Application: SSI 7485

I write regarding the proposed modification to M4-M5 Link, Mod 2 The Crescent overpass and changes to pedestrian infrastructure in North Annandale, Rozelle and Rozelle Bay Foreshore area.

Figure 4-2 Pedestrian and cyclist bridge infrastructure options

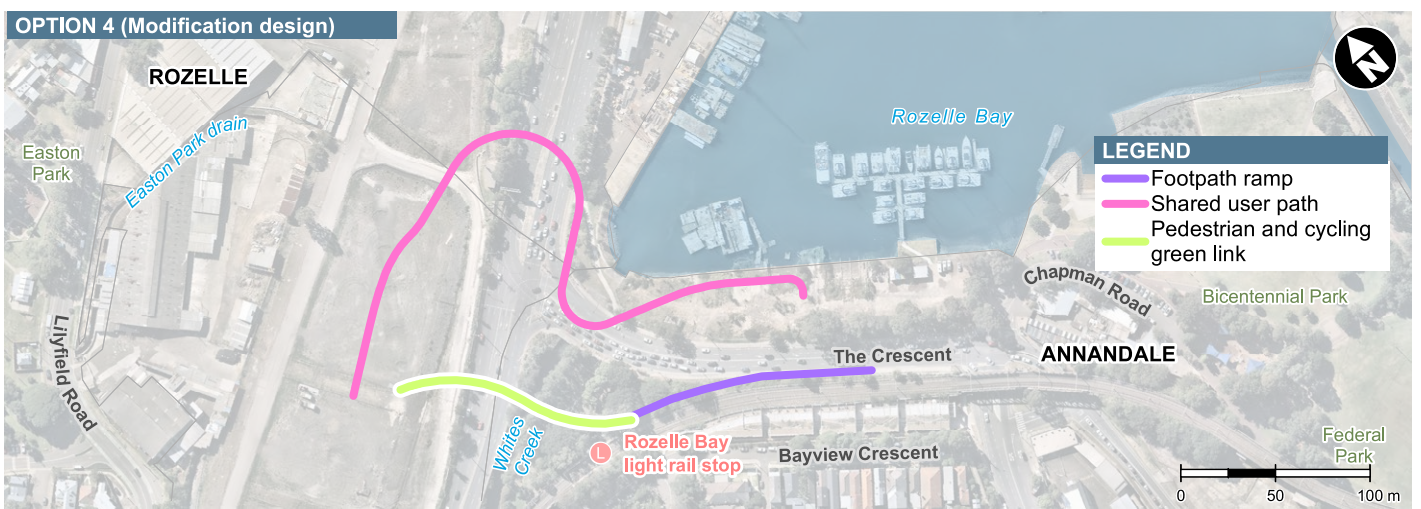
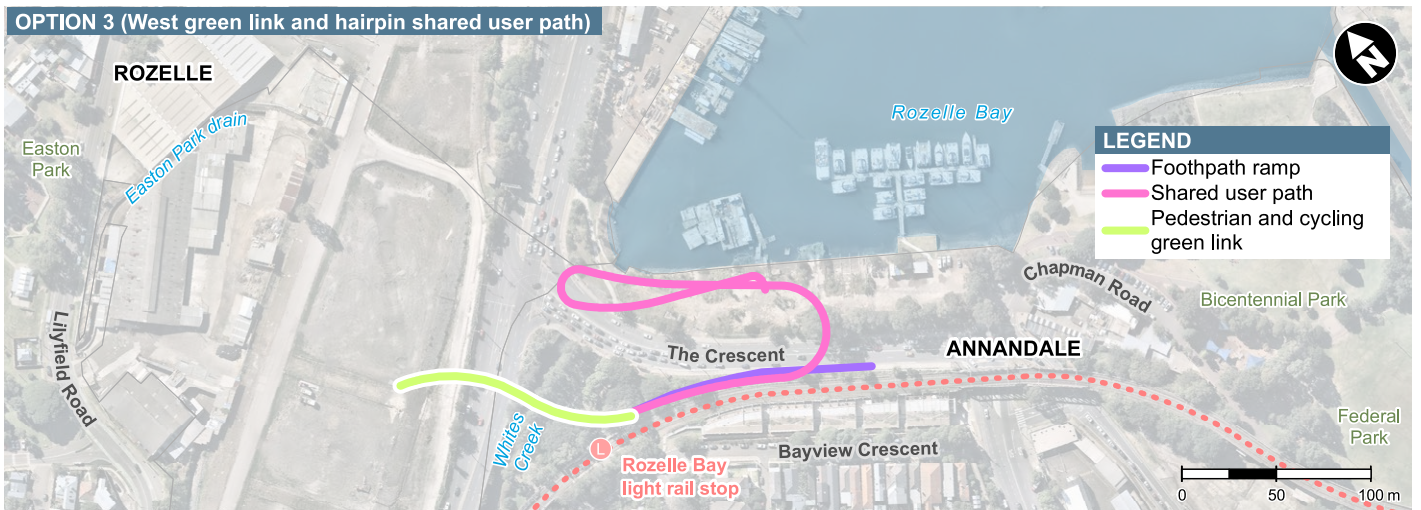
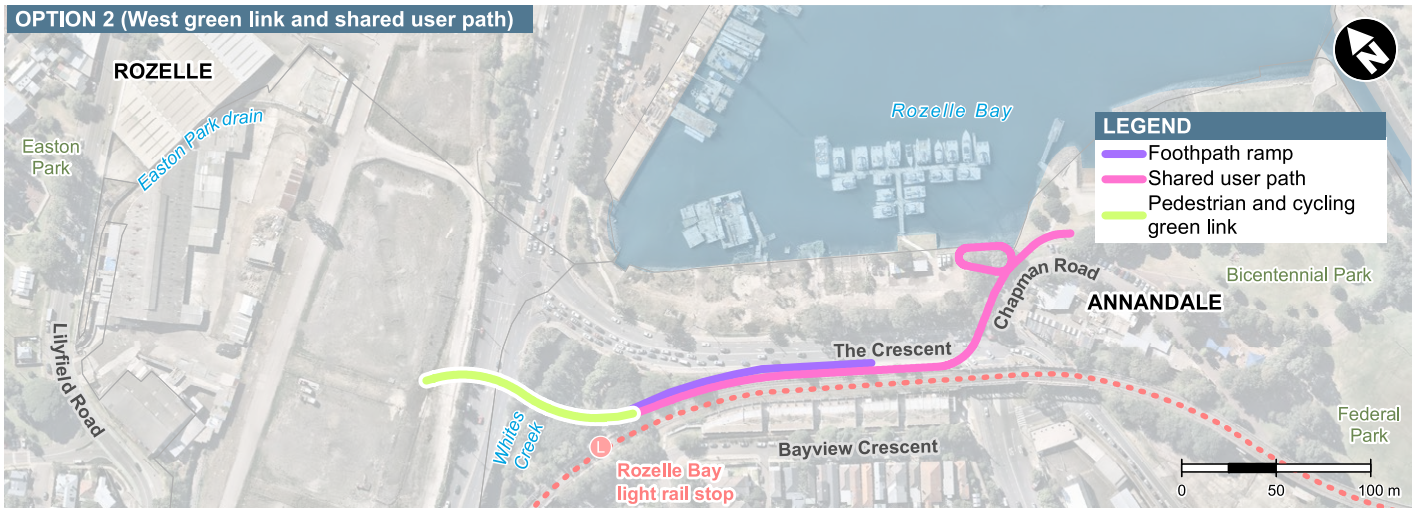
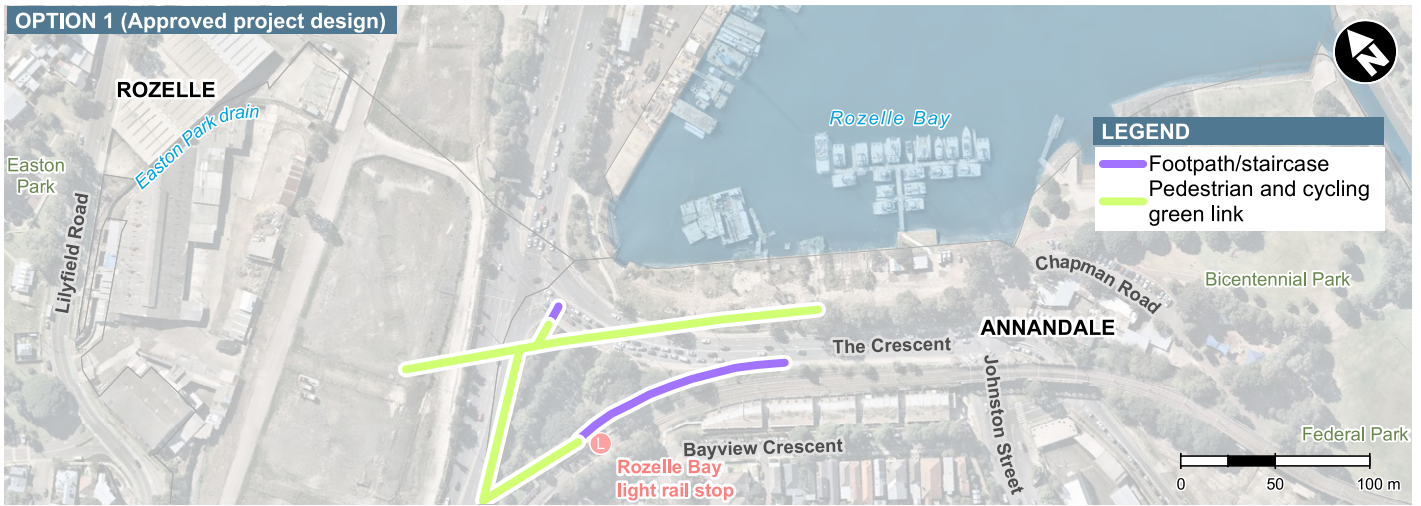
The overpass has significant visual and urban impacts. It has forced the relocation of the green bridge west of The Crescent requiring a pedestrian crossing of four traffic lights.

It has added another elevated pedestrian crossing from the same starting point in the new Goods yard parklands. This crossing is longer than it needs to be due to extra height required to get over the new vehicle overpass. These changes have greatly added to the visual impact and clutter.

- **Reinstate the GreenLink connecting communities and green open space from Rozelle to Bicentennial Park**

Directly connect pedestrians from the new Rozelle parklands with Rozelle bay and the Glebe foreshore.

Figure 4-3 The Crescent, Johnston Street, Chapman Road intersection options

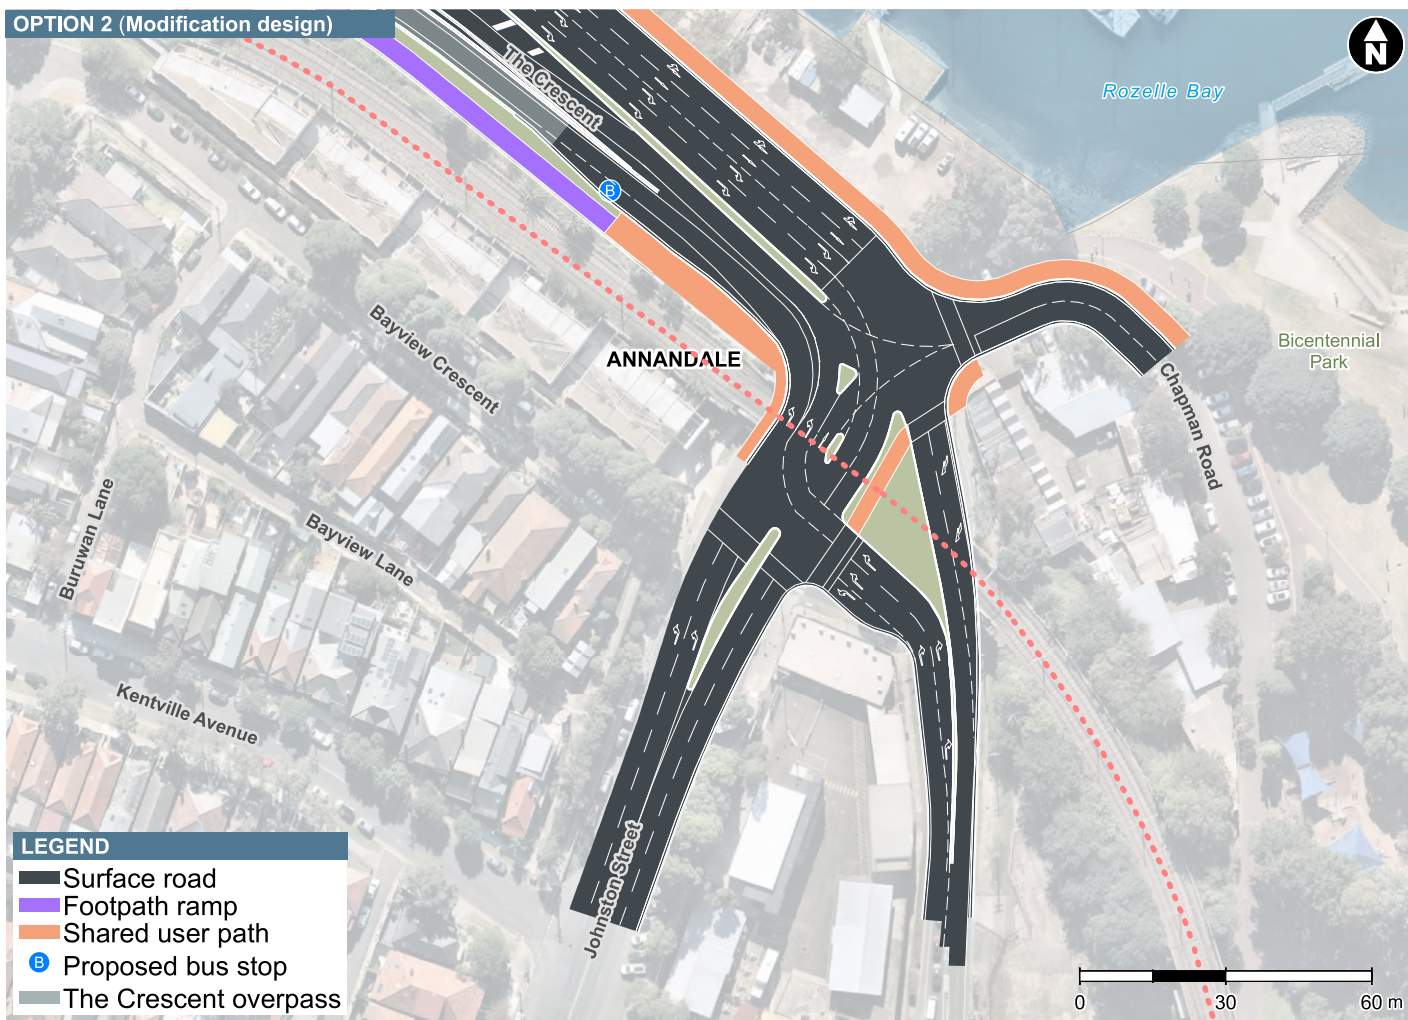
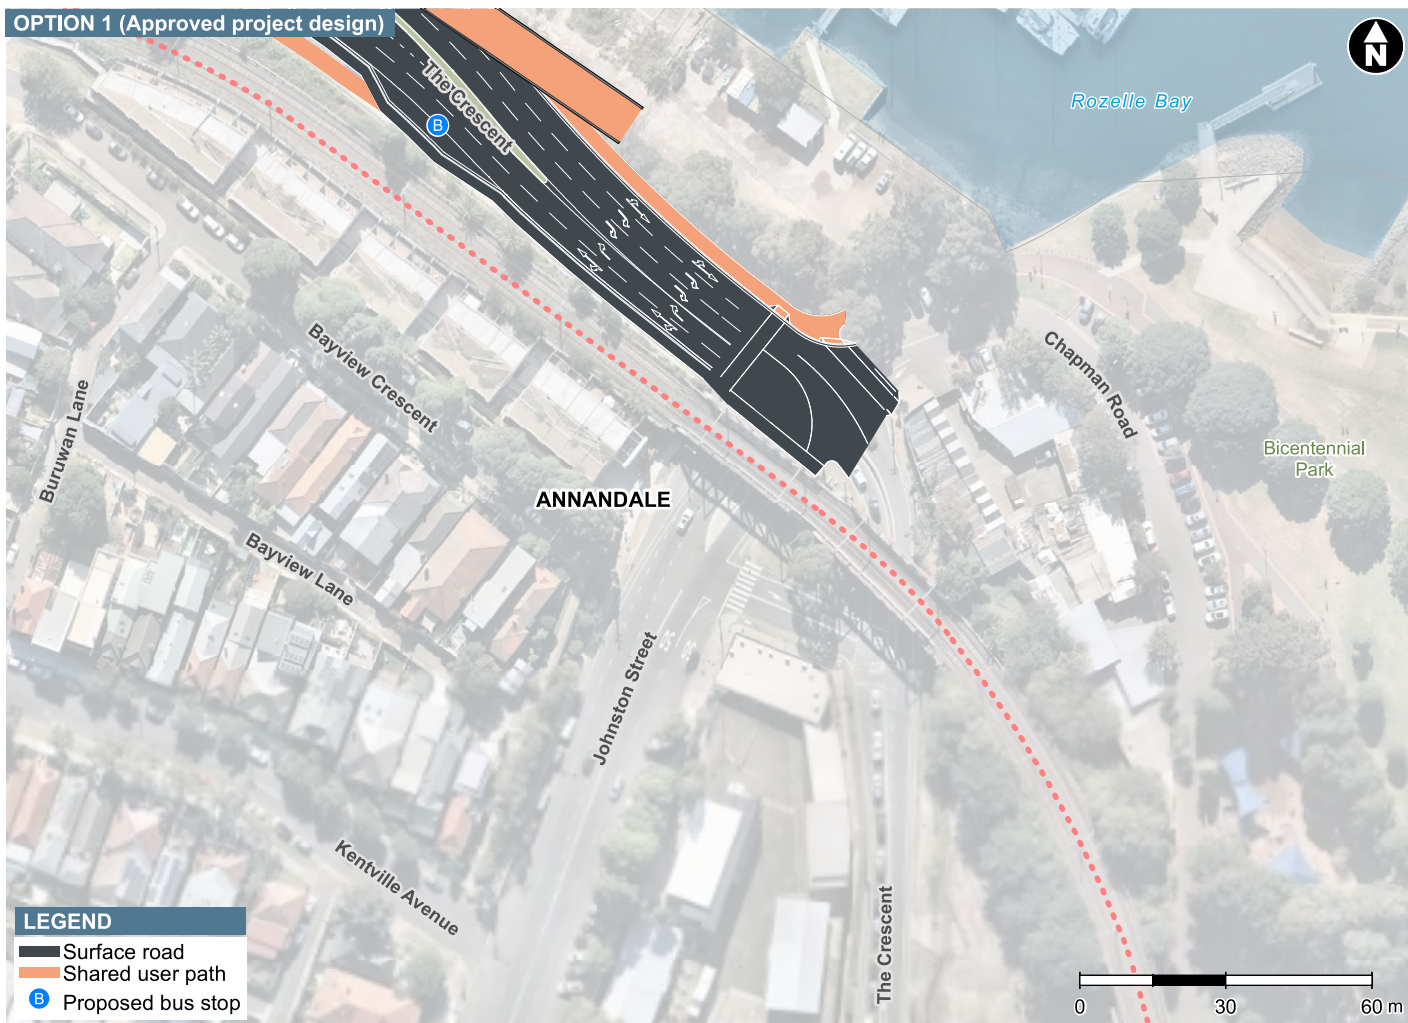
The proposal bottlenecks the majority of vehicle movements turning right to Victoria Road and the Anzac bridge from three lanes down to one lane with likely traffic impacts up Johnston street and The Crescent.

It doesn't allow a right hand turn into James Craig road.' From The Crescent heading city bound.

Return the Johnston Street / The Crescent pedestrian crossing to a single traffic light as per the current situation, and location.

- **Local traffic** Reinstate the right hand turn lane at the Crescent from Johnston Street.
- Design the modification infrastructure and active links in response to the character of the suburbs, the location of the foreshore and it's potential future development.
- Provide pedestrian and cyclist paths that maximise people safety and do not force them onto busier streets, unsafe concrete plazas and caged walkways.
- Integrate active and direct connections to all active transport – including the future Metro West and Foreshore Ferry Wharf.

Figure 4-4 Elevation: Indicative view of The Crescent overpass

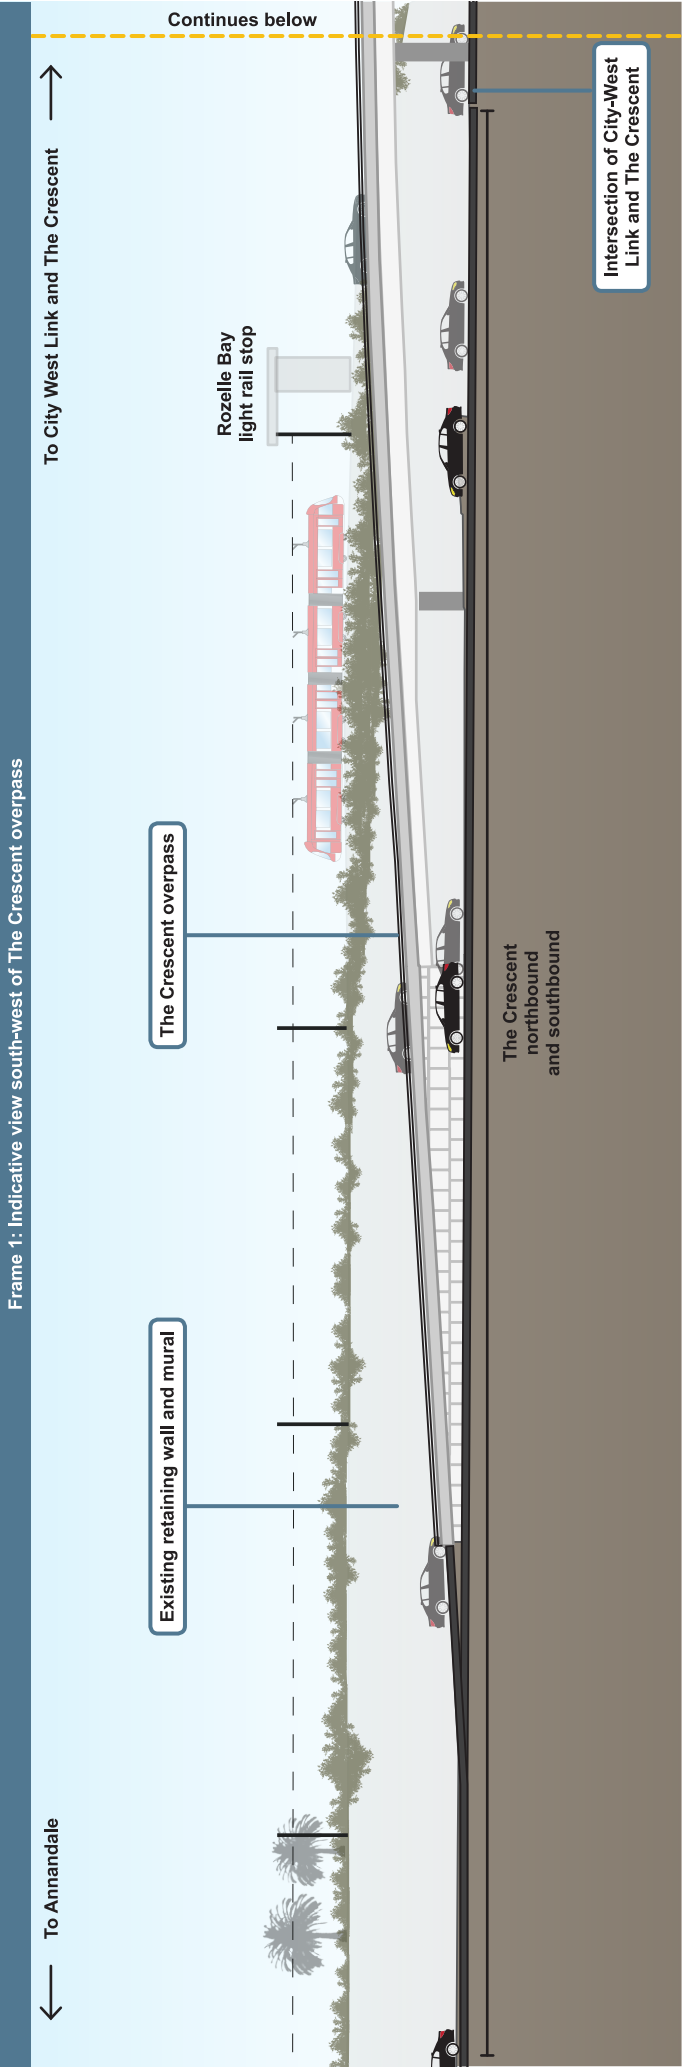
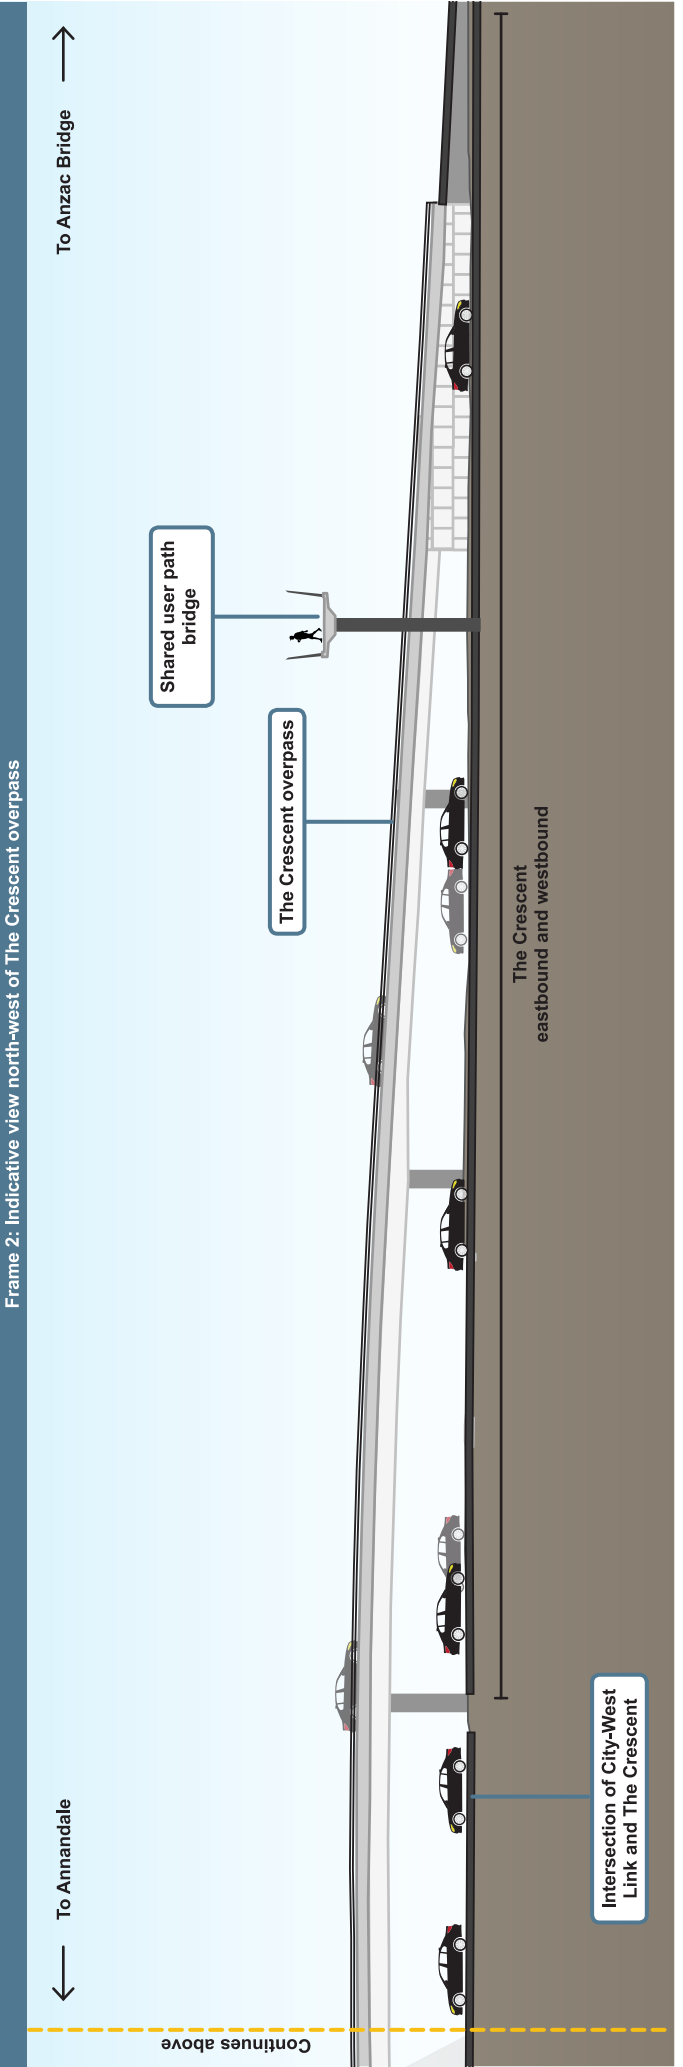
- **Respond to the local character** Respecting and maintaining the unique heritage, industrial character and topography of the Rozelle Rail Yards through interpretation. **A massive concrete overpass obstructing a historically significant local mural and concrete plaza — really?**

We object to the proposed overpass option. It has limited improvements to

vehicle waiting time, but these are outweighed by significant visual and pedestrian connectivity impacts.

It blocks views of the water from the relocated green bridge.

The overpass should be replaced with an at grade intersection as per the EIS or a short 120m tunnel option with a single land bridge option.

Change the overpass to a short (less than 120m) tunnel under the city West link with slot trench approaches rather than the proposed overpass. This underpass needs to be designed to also facilitate the single pedestrian crossing at Johnston's Street. An underpass provides the best visual and urban outcomes. It allows the retention of the green bridge in a location to best connect the parklands together.
